# **OXFORDSHIRE COUNTY COUNCIL'S RESPONSE TO CONSULTATION ON THE FOLLOWING DEVELOPMENT PROPOSAL**

**Application no:** 16/00627/REM-2

**Proposal:** Reserved Matters to 13/01811/OUT - Erection of 60 dwellings and public open space with associated works

**Location:** Land And Former Buildings UH11 442 465 466 467 468 470 471 481 492 493 529 593 596 Dow Street Upper Heyford

DETAILS: PROPOSED ENGINEERING LAYOUT
SHEET 1

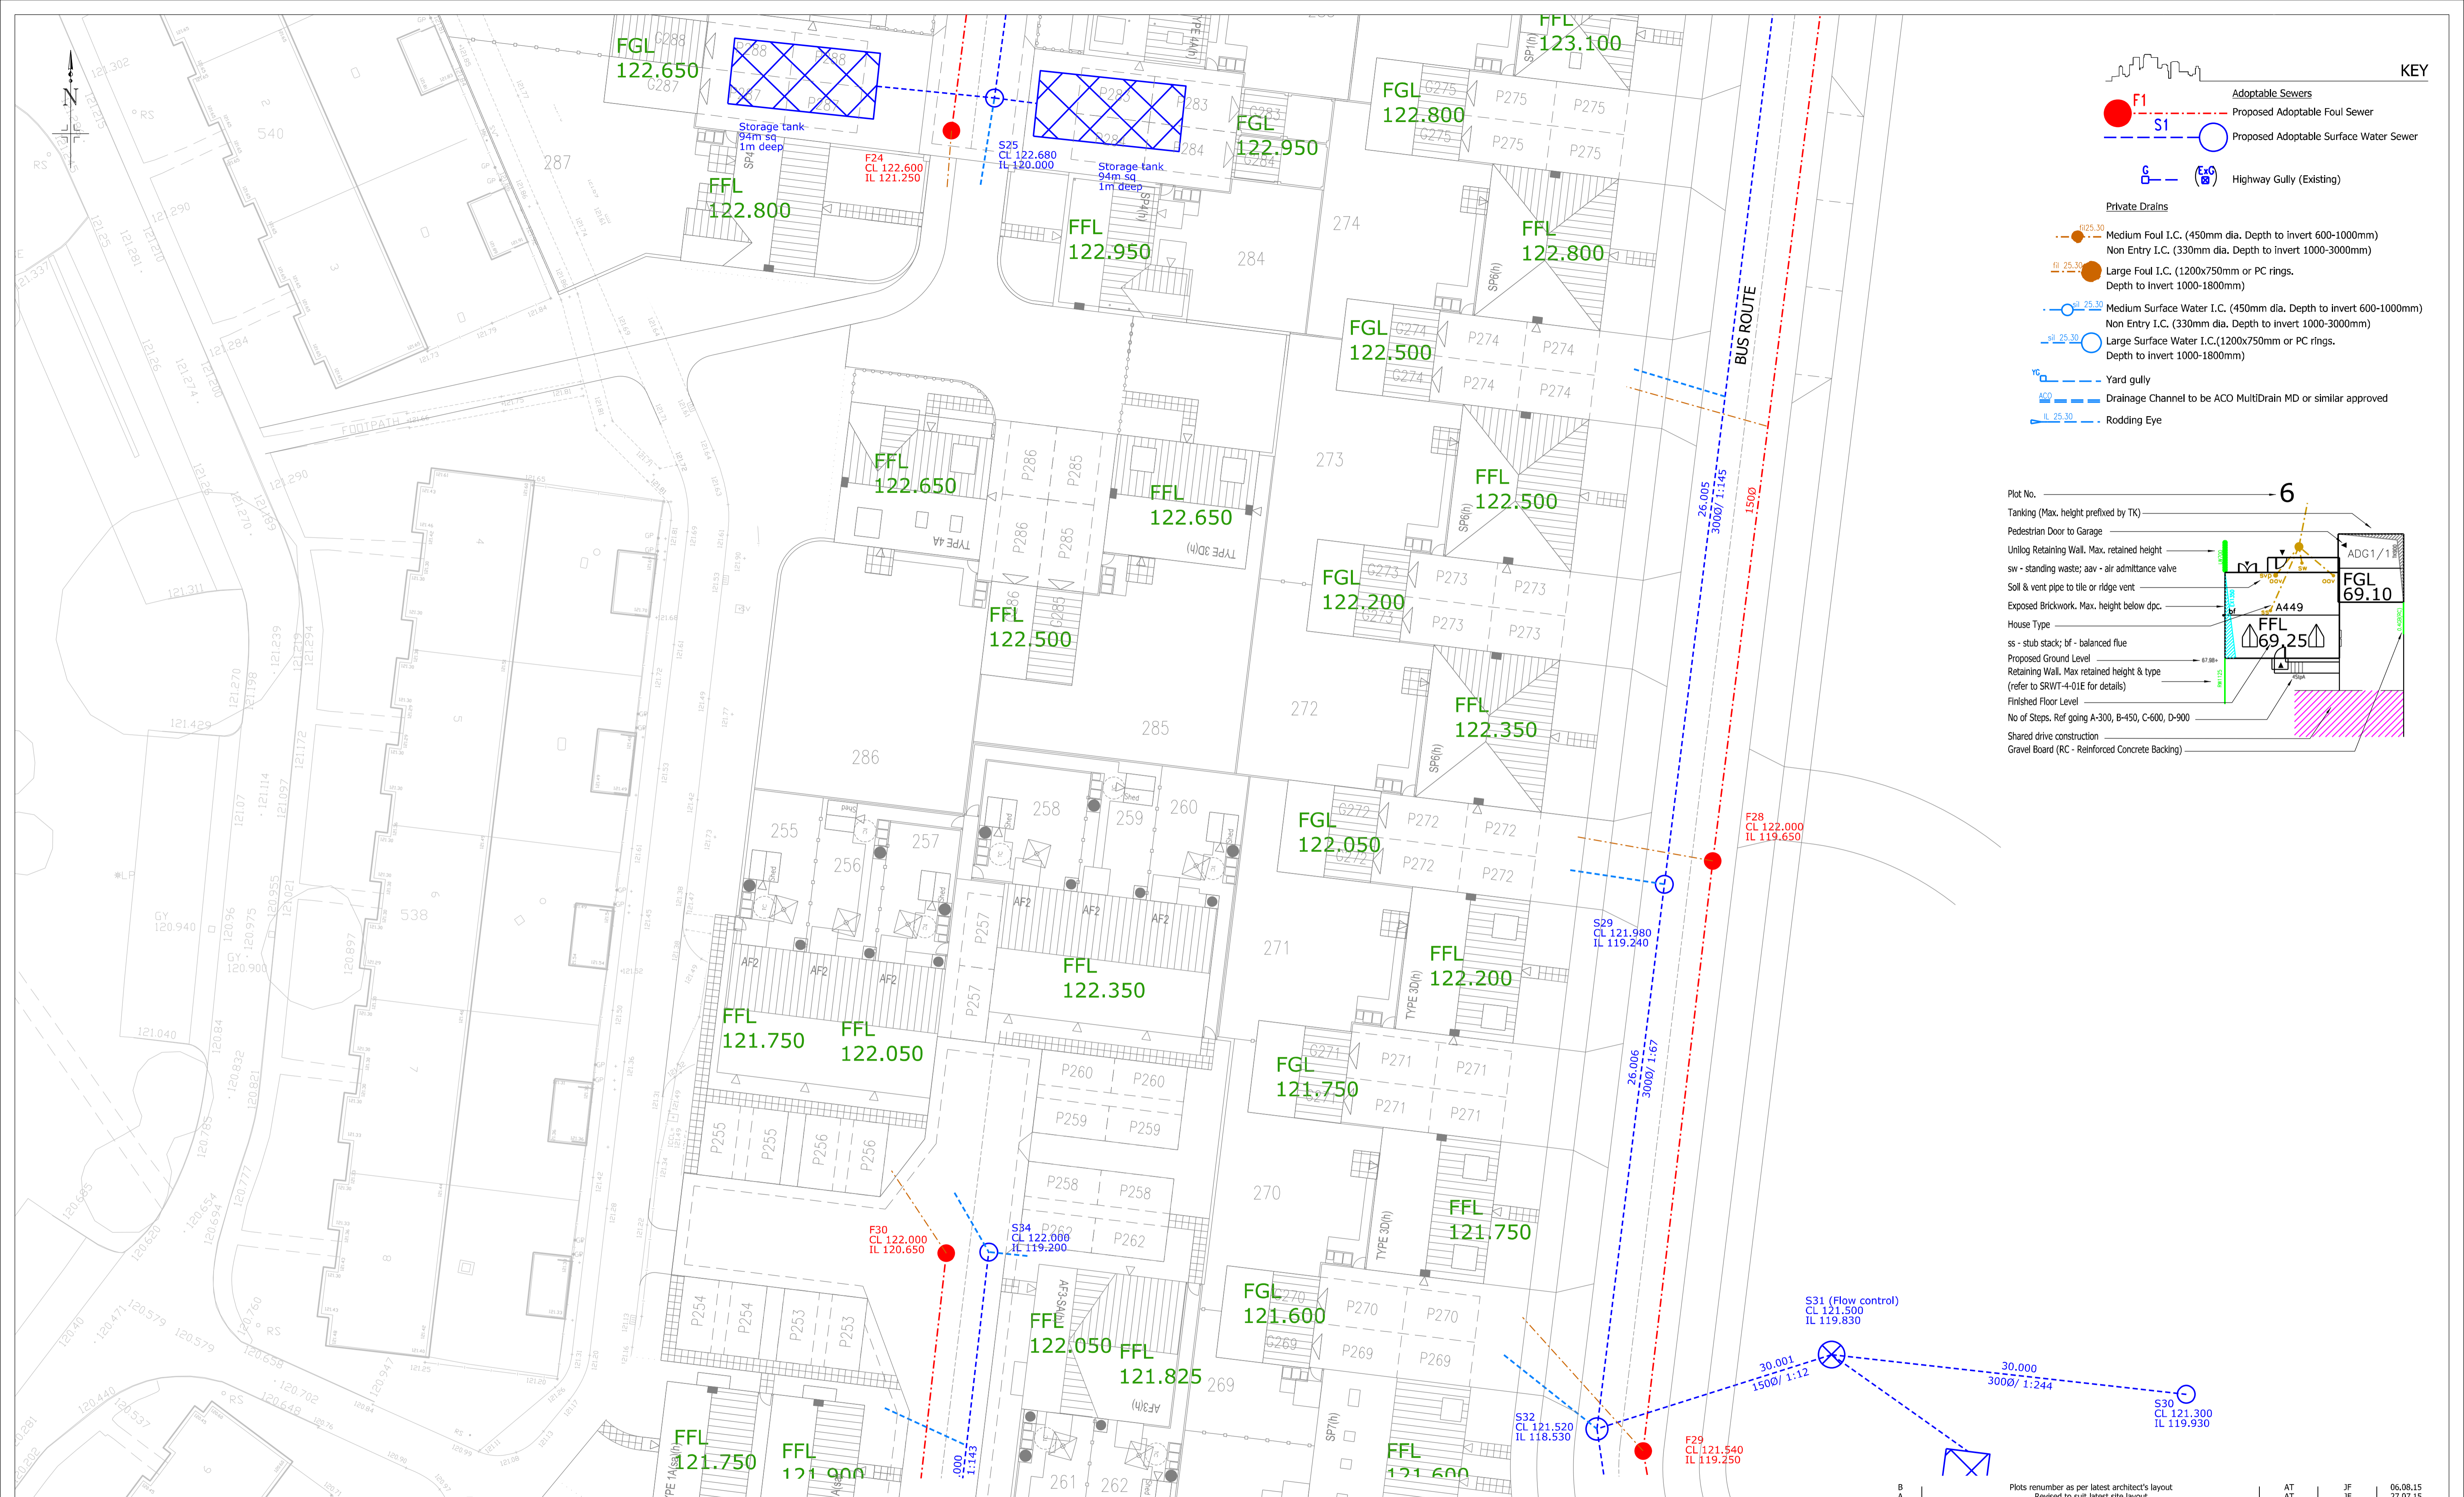
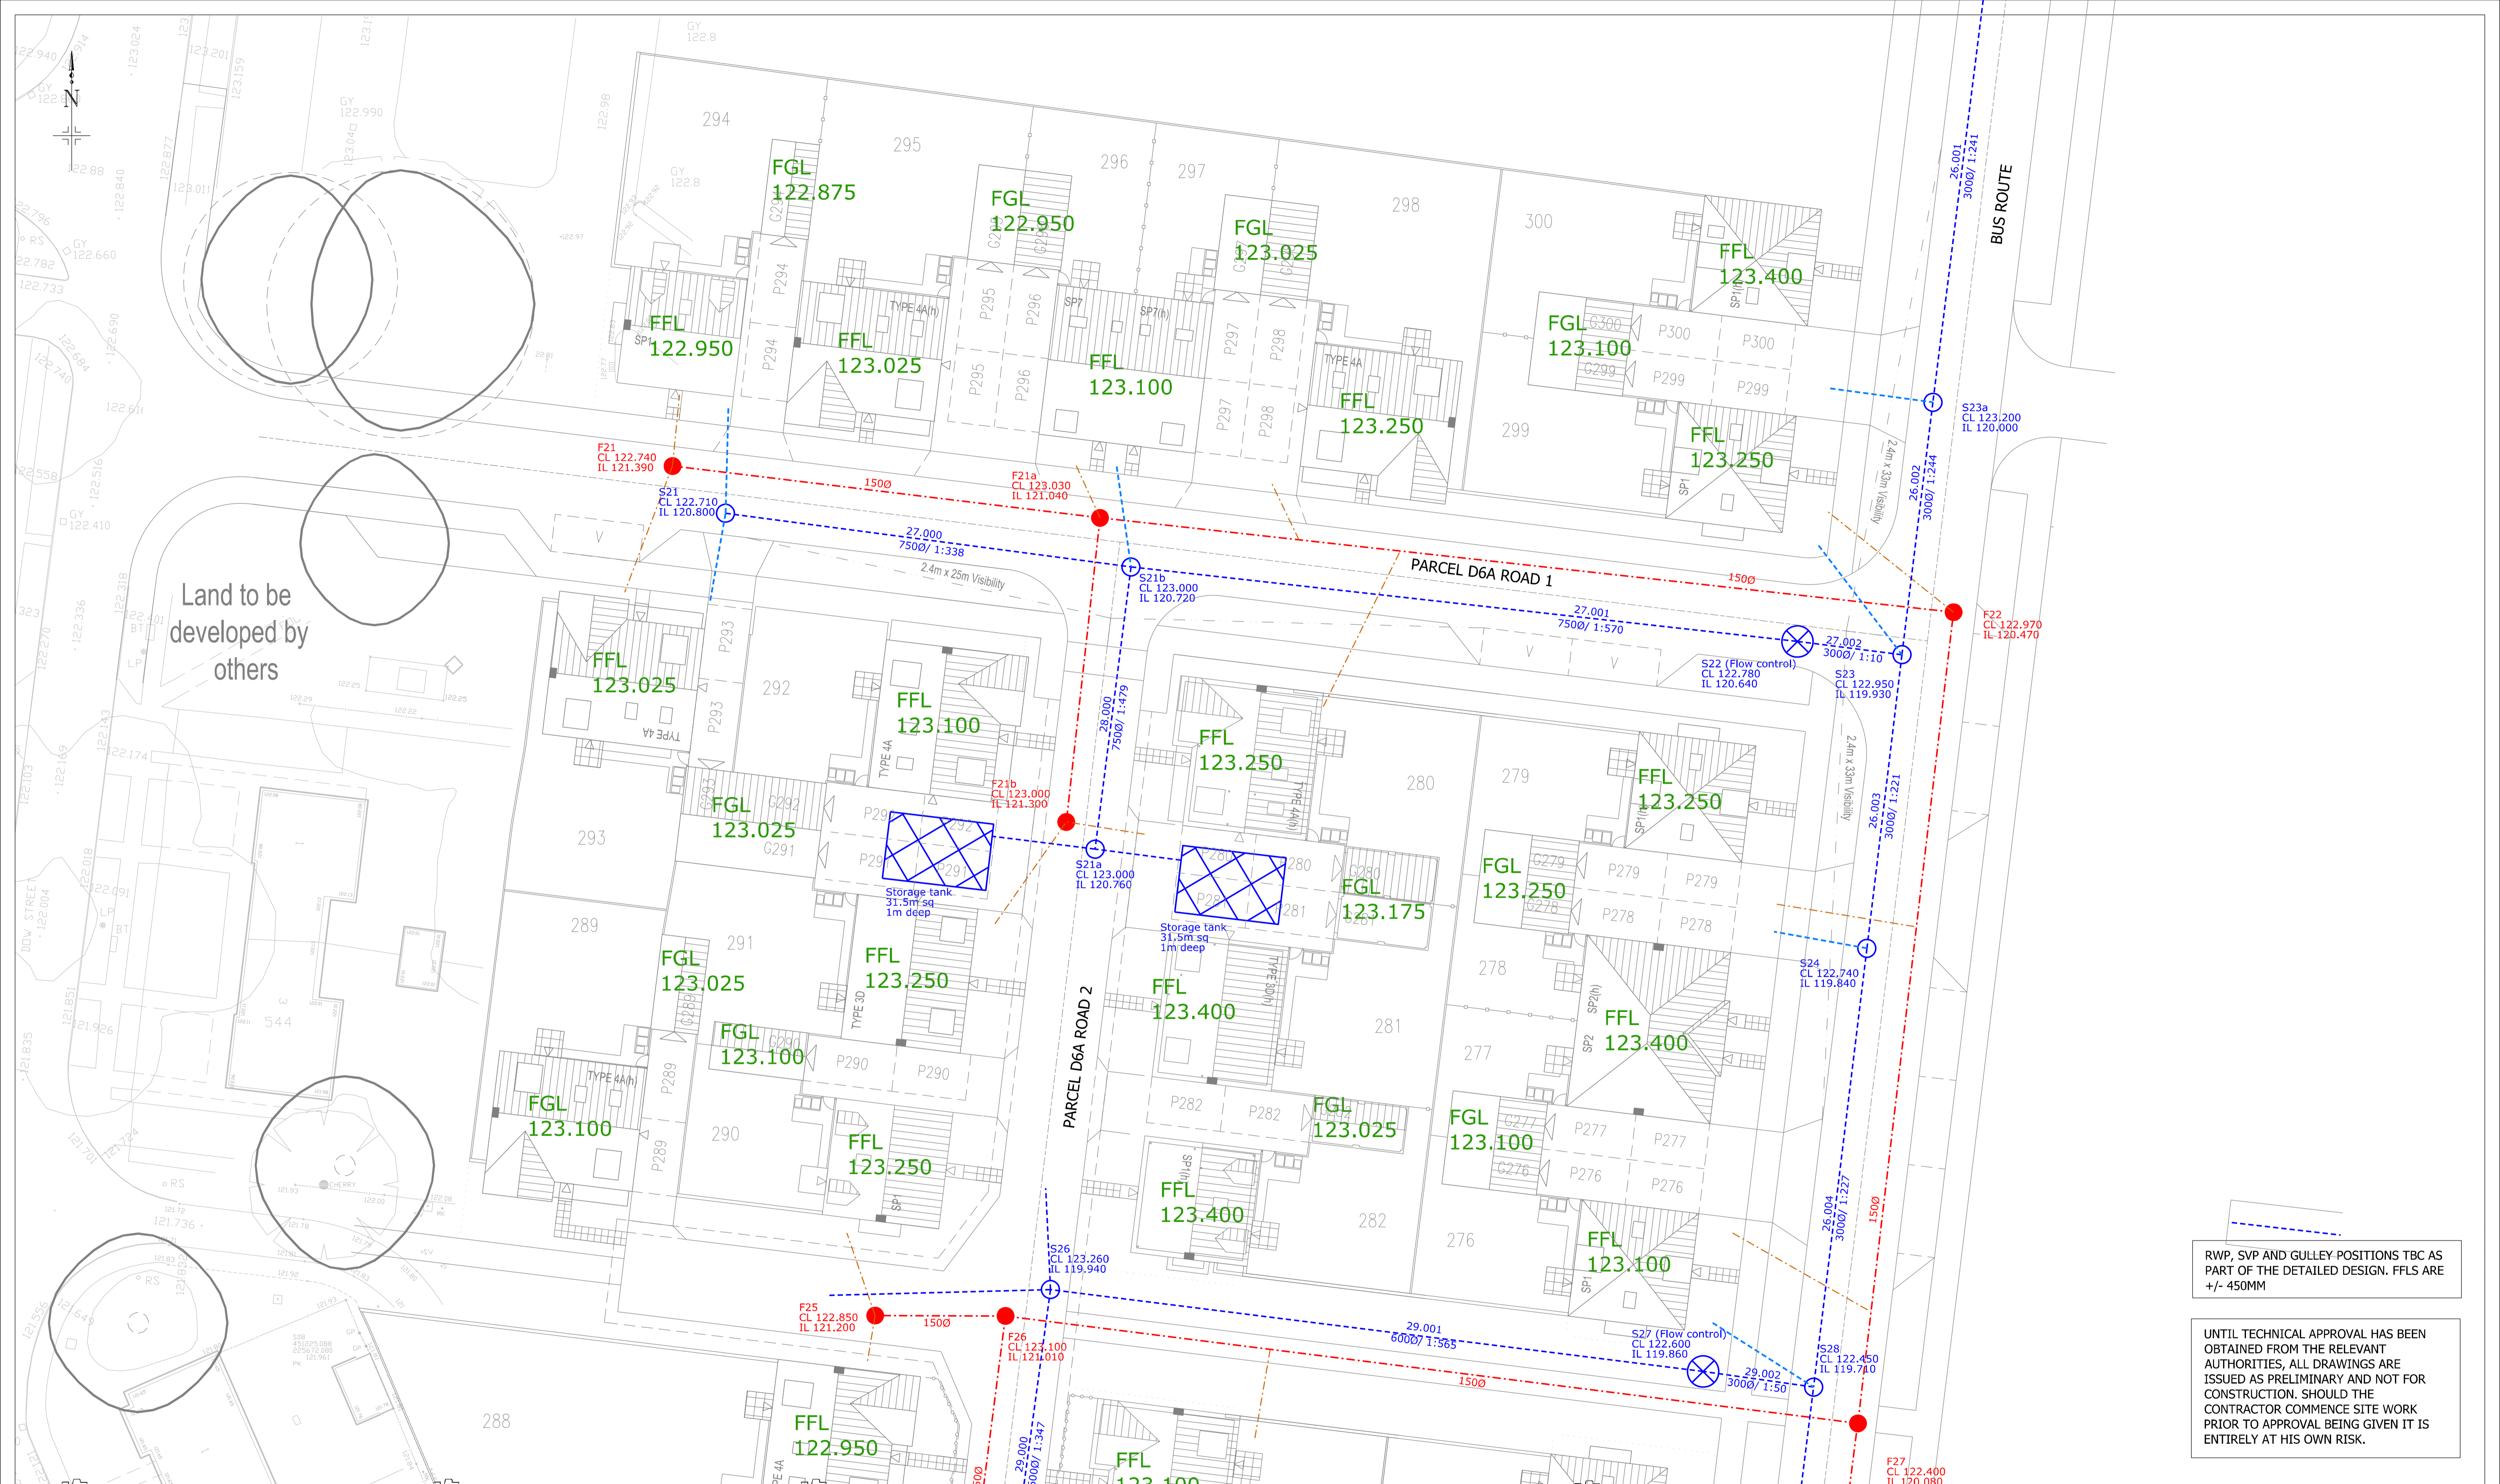
The XP drainage microsimulation modelling provided within the updated FRA (dated 2.6.16) Appendix C, would appear to show that well over 1000 m<sup>3</sup> of flooded volume occurs during the 1/100 year exceedance event. It is not clear where flooded volume will be stored on the site. **(Reason for Objection)** Please clarify paragraph 4.6 of the updated FRA and whether flood flows are routed along the Phase 5 road towards Phase 4. Please provide a flood route plan for exceedance events making storage areas.

Please provide detailed design of the outfall structure at the Gallos brook including section showing levels.
